**Consultation Response from KC,
Trees**

2026/90792 31, Deadmanstone, Berry Brow, Huddersfield, HD4 7QQ

Erection of two storey side extension and balcony, conversion of garage to habitable accommodation and associated alterations

Date Responded: 16/04/2026

Proposed Block Plan

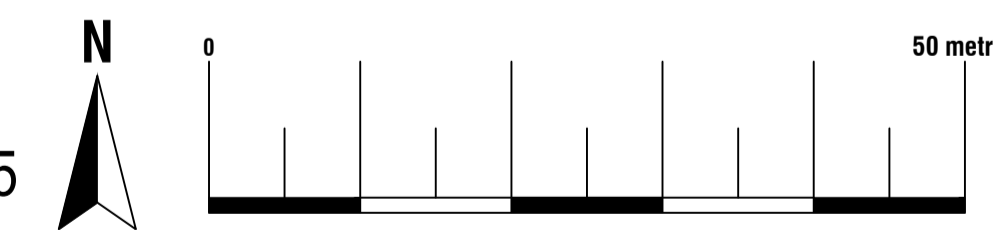
It appears from the plans submitted that there may be a direct impact on these protected trees either by damage within their Root Protection Area's (RPA's) by digging the foundations of the extension or by requiring trees to be removed or pruned to facilitate the proposals.

There is also likely to be an indirect impact on the trees because if the extension is built beneath the canopy there may be future pressure to have the trees pruned or felled to alleviate issues such as shade, seasonal detritus, or moss build up on the roof.

There has been no tree information submitted to clarify what the impact would be on the surrounding trees.

There is an objection from KC trees as the proposals currently pose potential direct and indirect impacts on the neighbouring protected trees.
